WEST SUSSEX COUNTY COUNCIL CONSULTATION

TO:	Arun District Council FAO: Andrew Wood
FROM:	WSCC - Highways Authority
DATE:	29 June 2020
LOCATION:	Land adjacent to 45 The Ridings, East Preston, BN16 2TW
SUBJECT:	EP/67/20/PL 1 No. detached house & formation of associated new access.
DATE OF SITE VISIT:	N/A
RECOMMENDATION:	Advice
S106 CONTRIBUTION TOTAL:	N/A

DRAWING TITLE
PROPOSED SITE LAYOUT

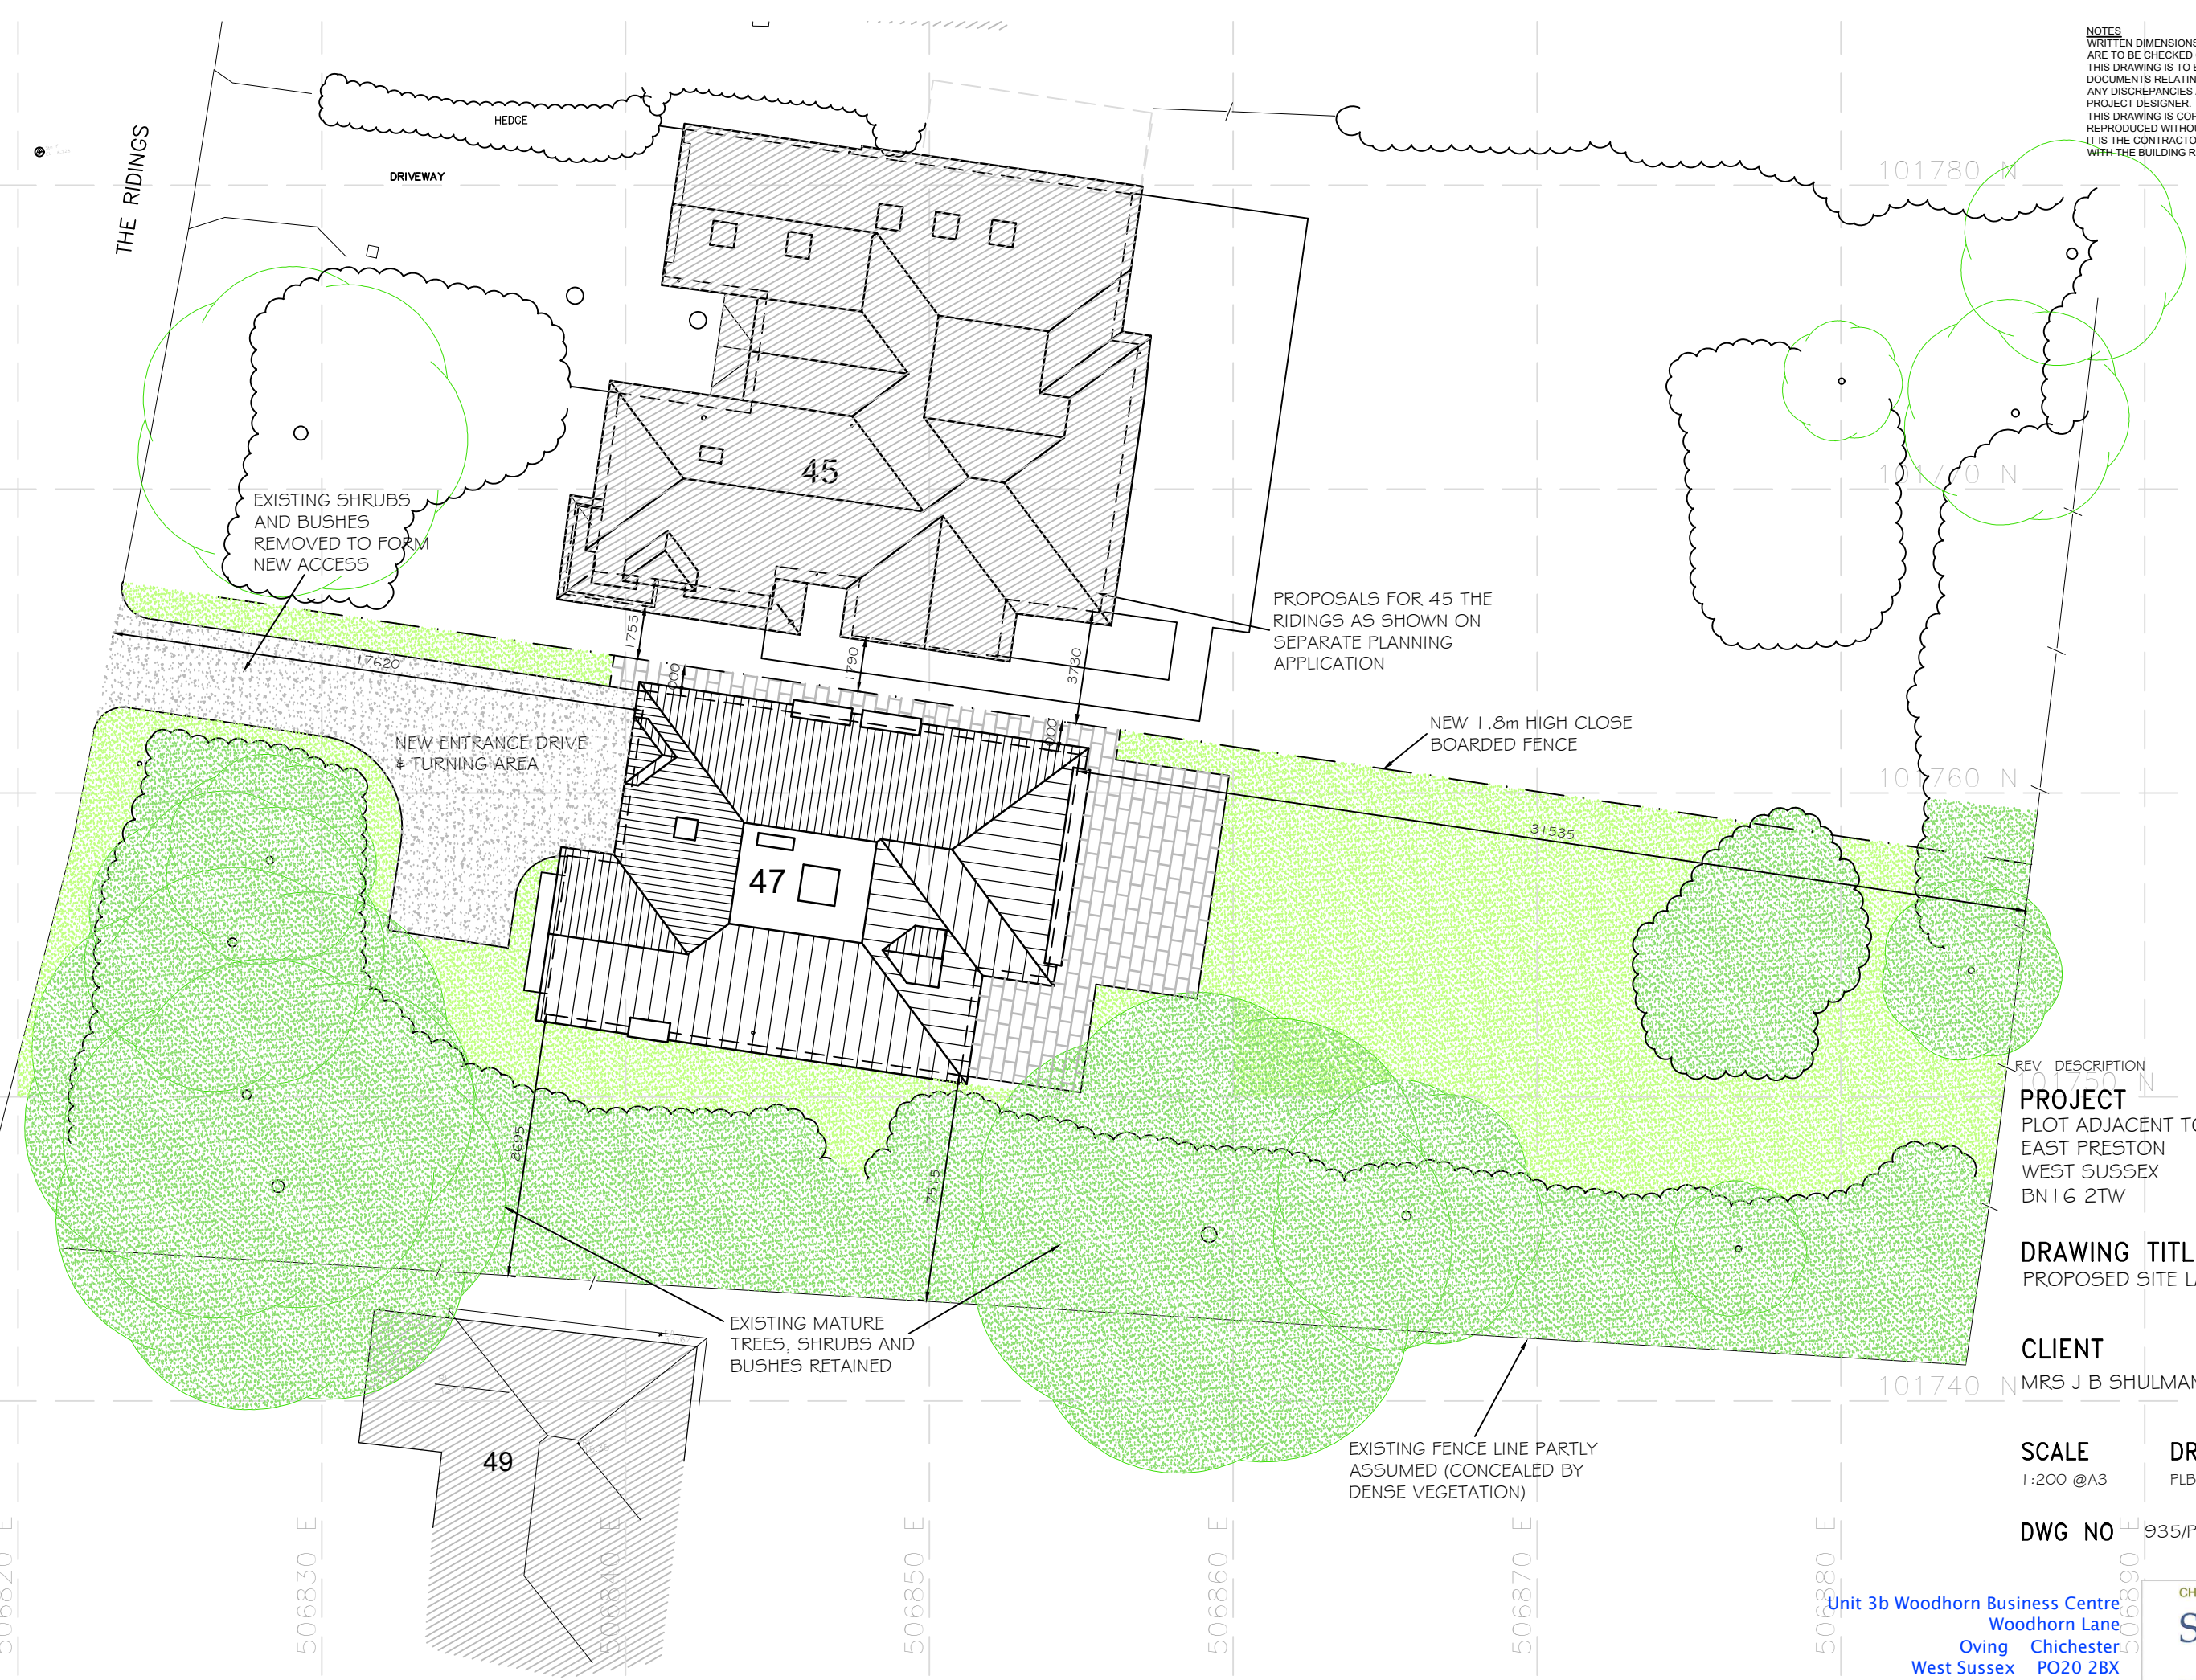
The applicant proposes a new 3m wide vehicular access for the proposed dwelling. The applicant should contact the proprietor of the privately maintained road to obtain formal approval for the proposed access works.

The applicant proposes a single garage and driveway for vehicular parking provision. Under Arun Parking Standards (Jan 2020), a dwelling of this size in this location should provide parking provision for at least three cars. From inspection of the plans, there is sufficient space within the proposed site for three spaces.

The provision of a turning head will allow for vehicles to turn and exit the site in a forward gear.
